Application: SSI 7485

I write regarding the proposed modification to M4-M5 Link, Mod 2 The Crescent overpass and changes to pedestrian infrastructure in North Annandale, Rozelle and Rozelle Bay Foreshore area.

**Figure 4 | Proposed modification** (Source: Design Amendment Report)

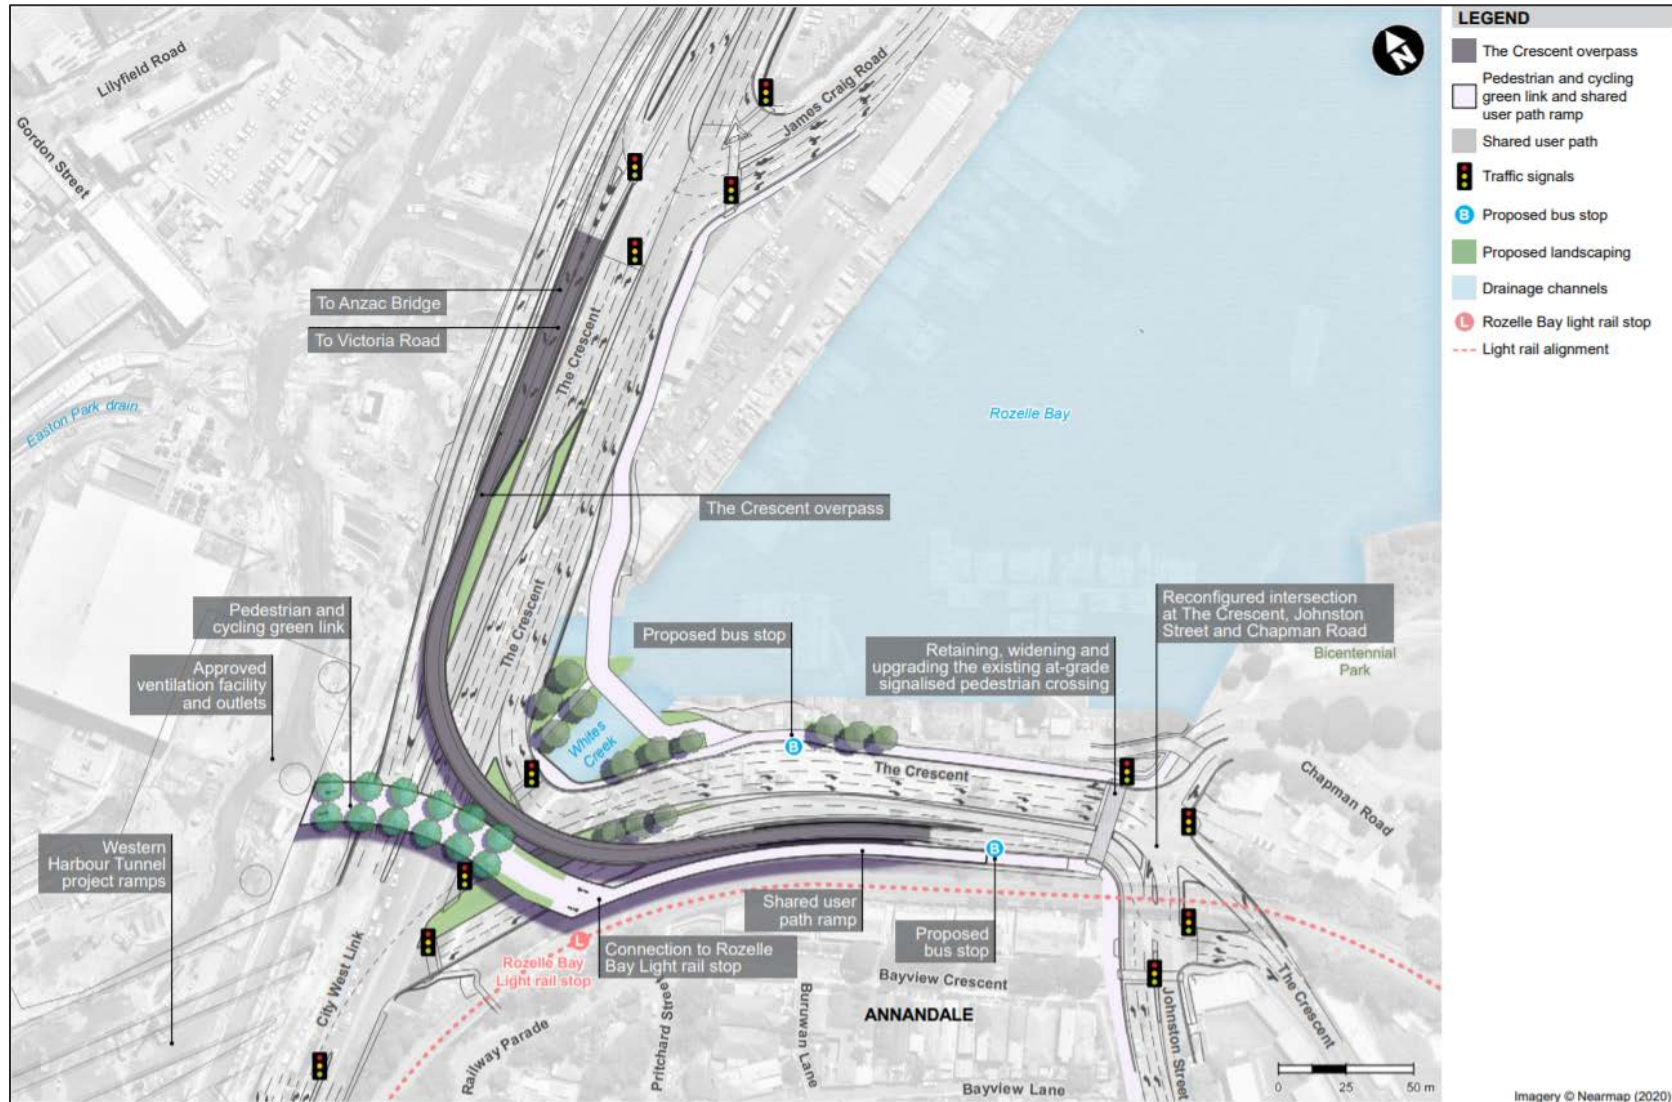
I request RMS work with the community to explore alternate design options to the proposed new car overpass design and the changed pedestrian and cyclist links. I am seeking the reinstatement of the safe, direct access from the approved EIS GreenLink to create a continuous green open space connection from the Rozelle Rail yards and Annandale to the foreshore. The GreenLink was more than just a walk way - it put people central to the design, maximising safety, and providing much needed accessible open space for the community now and into the future Bays Precinct design.

- The significantly reduced safety and increased risk for pedestrians and cyclists with removed access over The Crescent to Bicentennial Park and the increased traffic along Johnson Street.
- Being required to cross five sets of pedestrian lights at The Crescent as my option to reach the foreshore from Annandale or from Rozelle Bay light rail stop.
- Removal of direct active links to the foreshore, cutting the community off from the area and the proposed revitalisation of the entire Bays Precinct, including linking the Light Rail and Bus stops to a Ferry wharf and Metro station.
- Urban and landscape design that is being built before a finalised Masterplan for the area.
- Traffic changes that limit movements around the suburb and create further congestion in the local streets of Annandale, Forest Lodge, Glebe, Lilyfield and Rozelle with no planning to deal with these.

- Reinstate the GreenLink connecting communities and green open space from Rozelle to Bicentennial Park
- Relocate and design pedestrian and cyclist connections that are continuous, safe and direct.
- Design the modification infrastructure and active links in response to the character of the suburbs, the location of the foreshore and it's potential future development.
- Provide pedestrian and cyclist paths that maximise people safety and do not force them onto busier streets, unsafe concrete plazas and caged walkways.
- Integrate active and direct connections to all active transport – including the future Metro West and Foreshore Ferry Wharf

**Figure 6 |** Indicative view of Rozelle Rail Yards pedestrian and cycling green link  
(Source: The Crescent Overpass Modification Report)

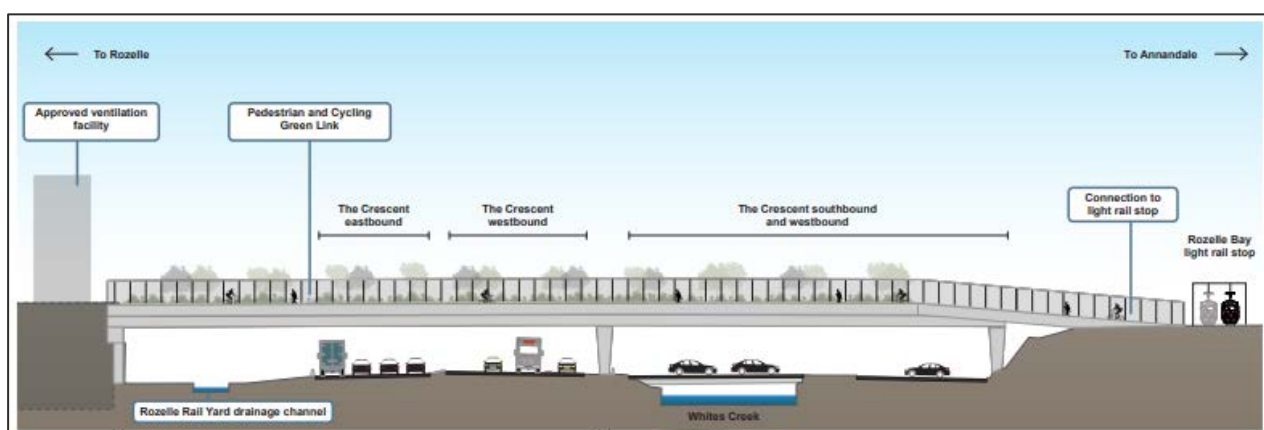
To ensure the sustainability of this area, providing environmentally friendly public spaces in which the local people can walk their dogs, exercise, play sports and have a ~~go~~ connection to green land. By the initial proposal of the GreenLink, a compromise of ~~urban~~^{green} and urban/industrial ^{was} met, ensuring the wants and needs of the community. Now, with this new development proposal, there is no benefits of green space for the local community and will have devastating impacts on the environment.
